Your ref: K/19/19/HH

Re: Proposed re-development of Little Tangle, Kingston Gorse

I am writing to you on behalf of the Board of Kingston Gorse Estate (Sussex) Ltd. to register an OBJECTION to the proposed development of Little Tangle, Middle Way Kingston Gorse.

Proposed First Floor Plan

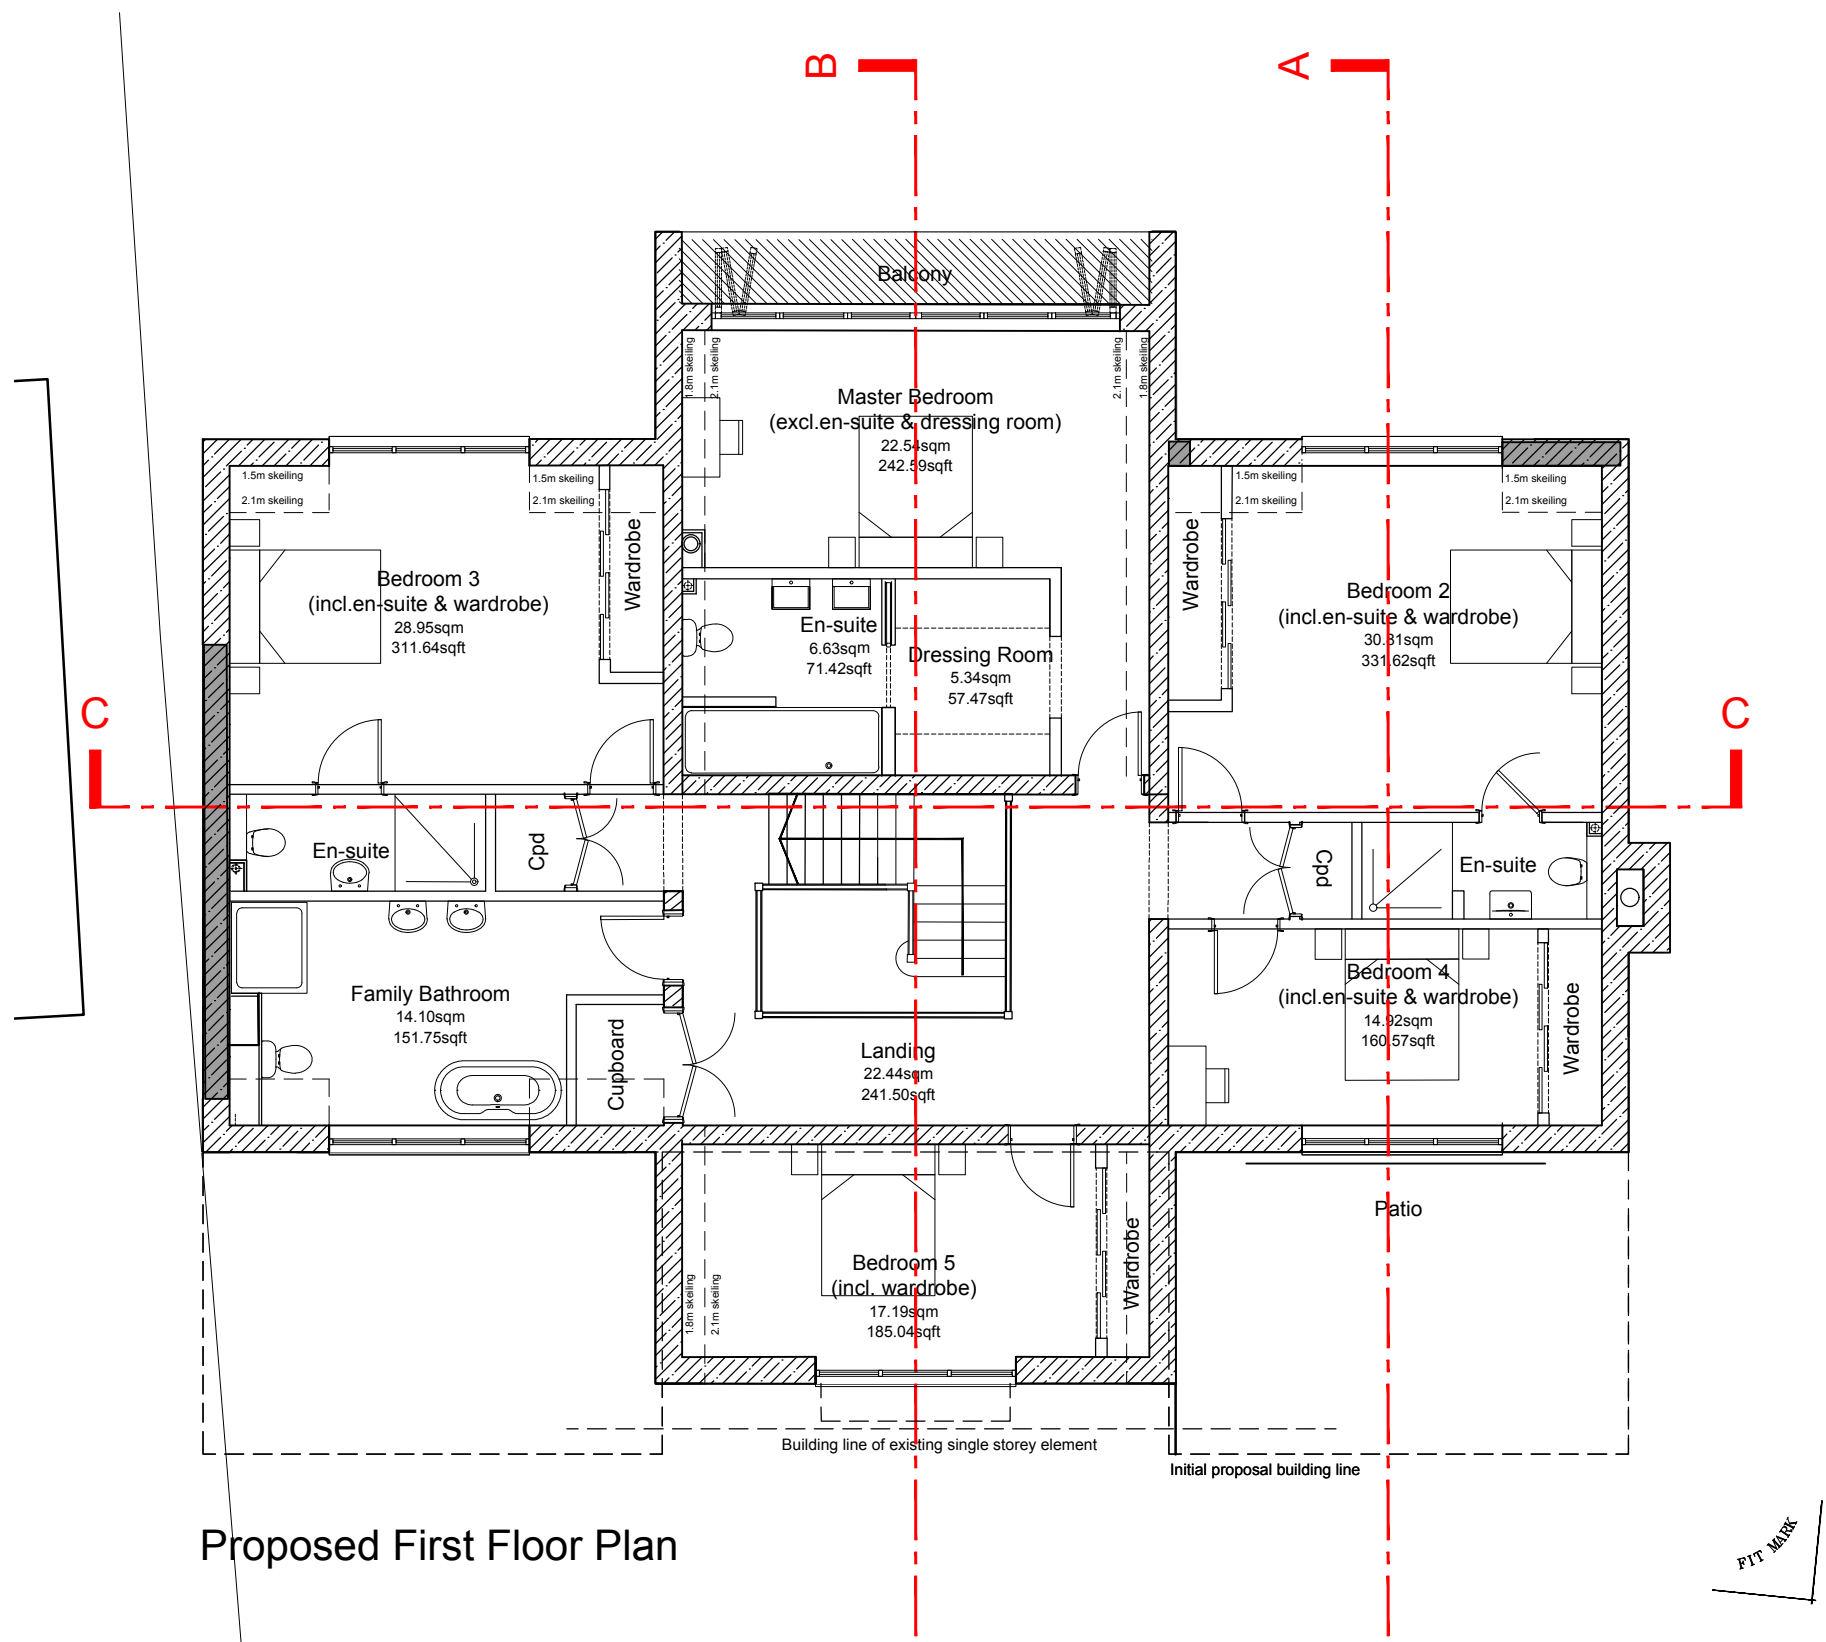
Overshadowing and loss of light will also impact on Poynings due to the balcony to be installed on the north side of the property extending beyond the building line of Poynings.

Both Clova and Poynings will also suffer from a lack of privacy due to windows overlooking the front gardens of both properties from the second storey of Little Tangle.

Drawing Title
Proposed Sections

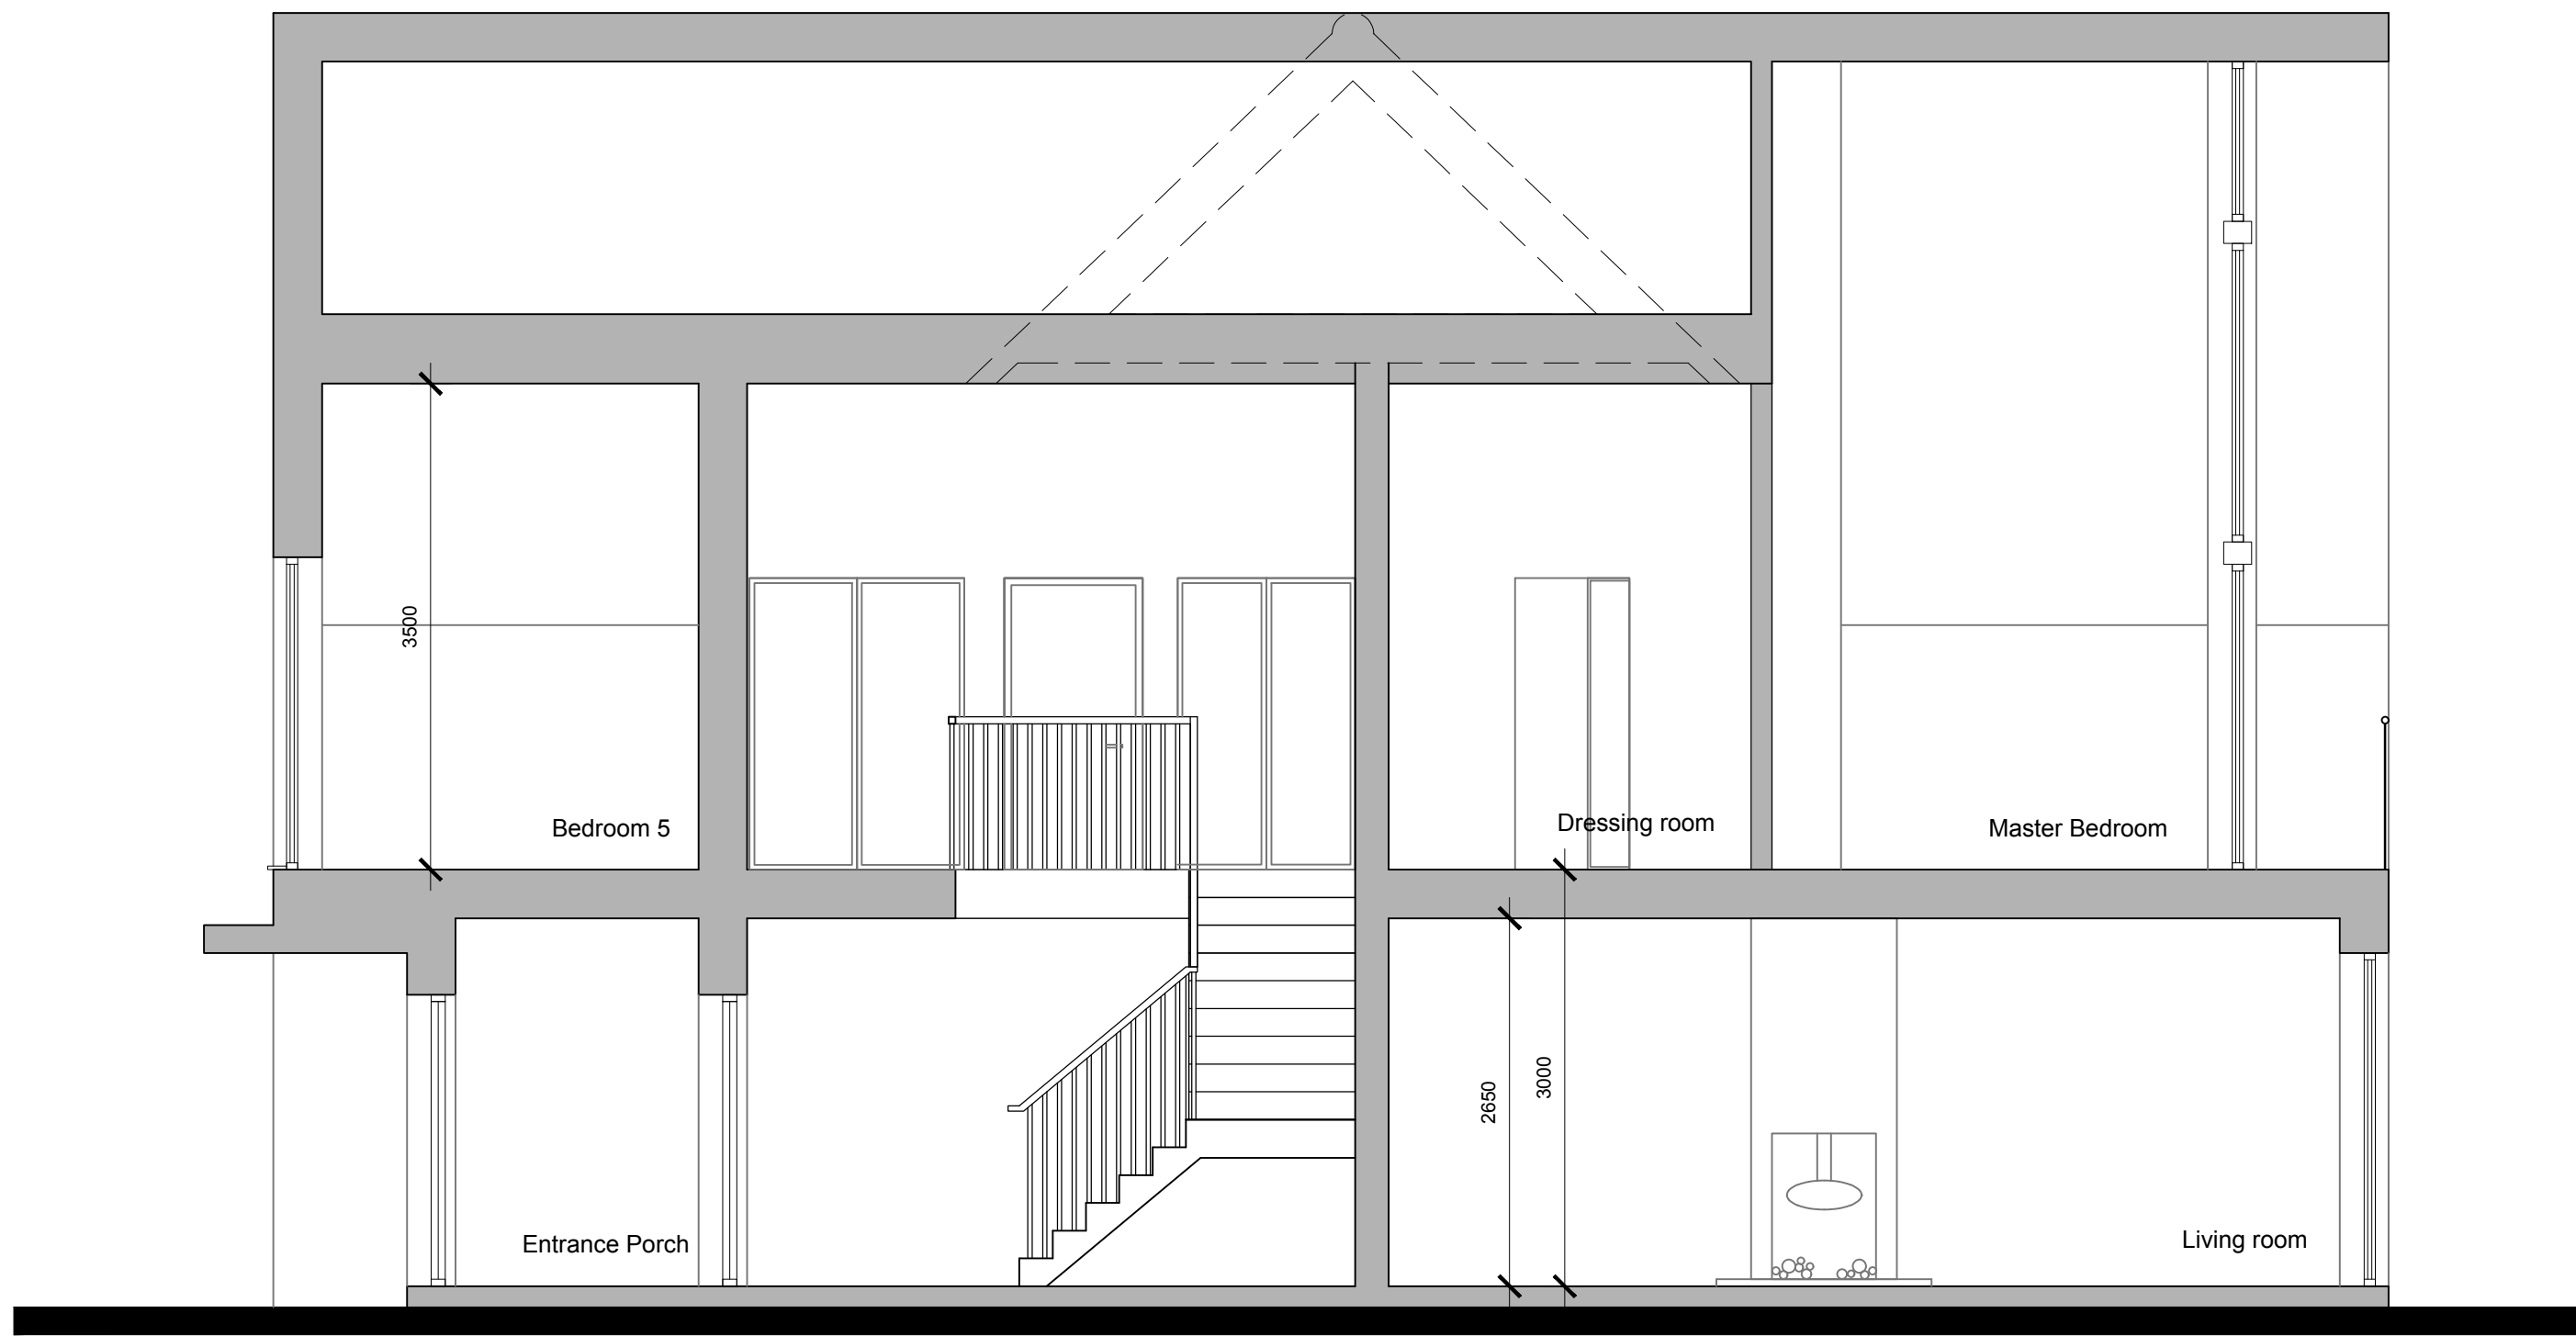
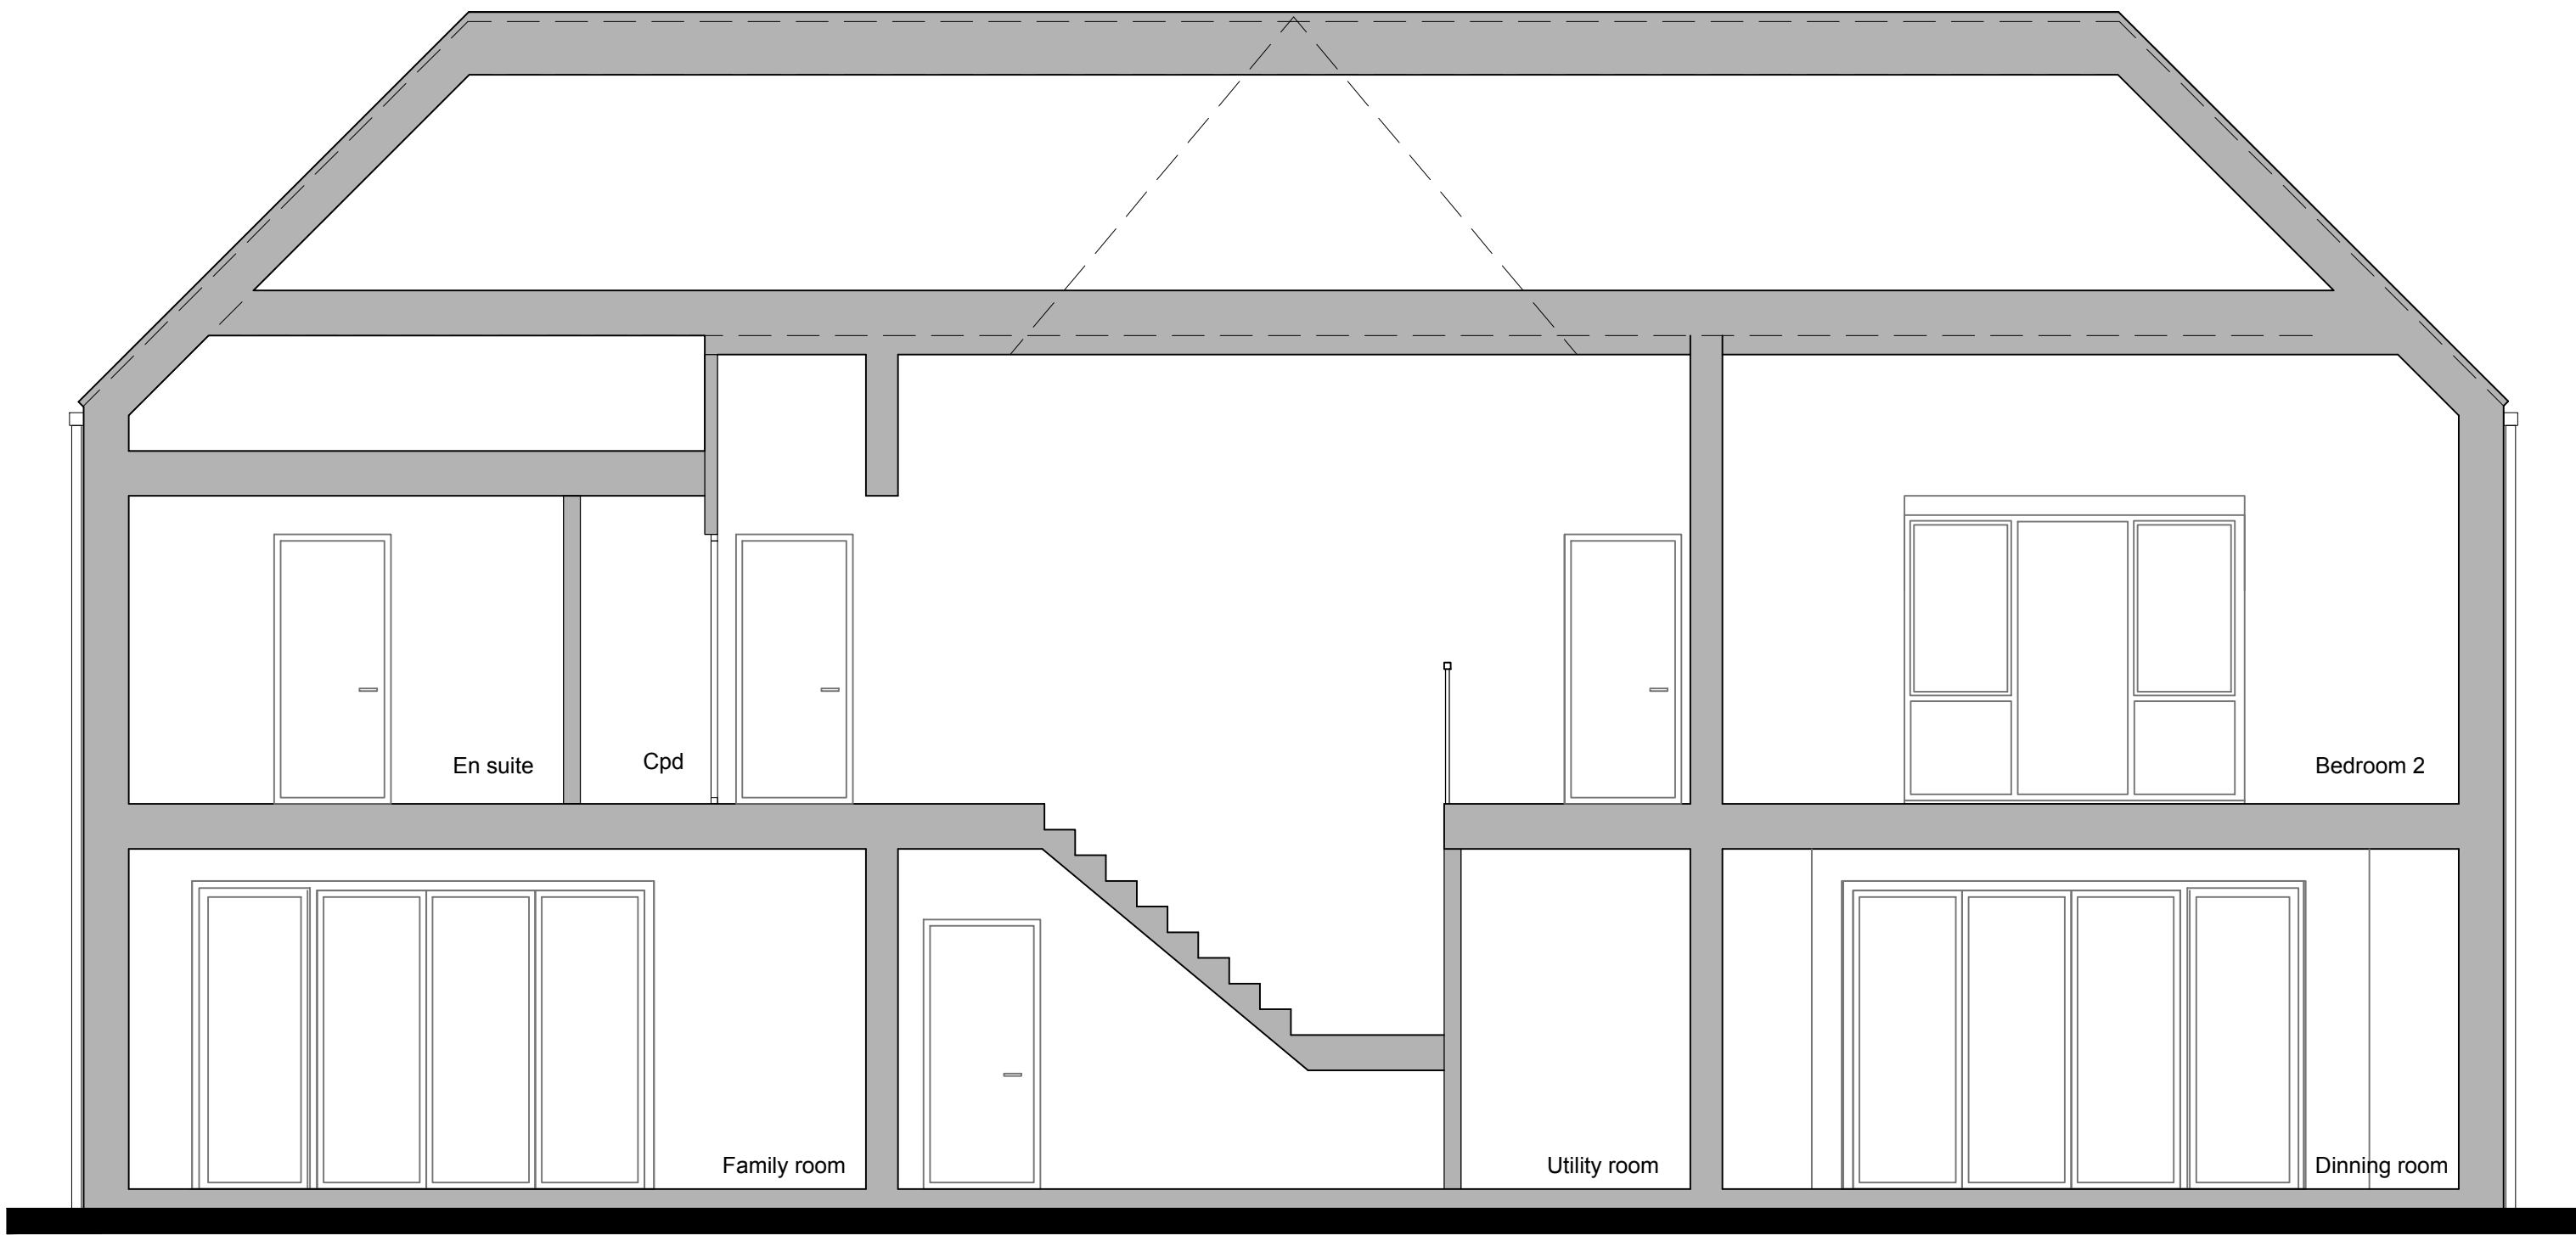
The existing property is a dormer bungalow, which is to be replaced by a two-storey dwelling. The proposed ridge-line of the new property will be increased by over 31%, from 11.61m to 15.27m. The existing single storey sun room will be replaced by a two-storey gable entrance to the house. Both these features will lead to a loss of light, particularly for the residents of Clova, where the kitchen window will now be obscured by the higher elevations, which will also impact on the view from the window.
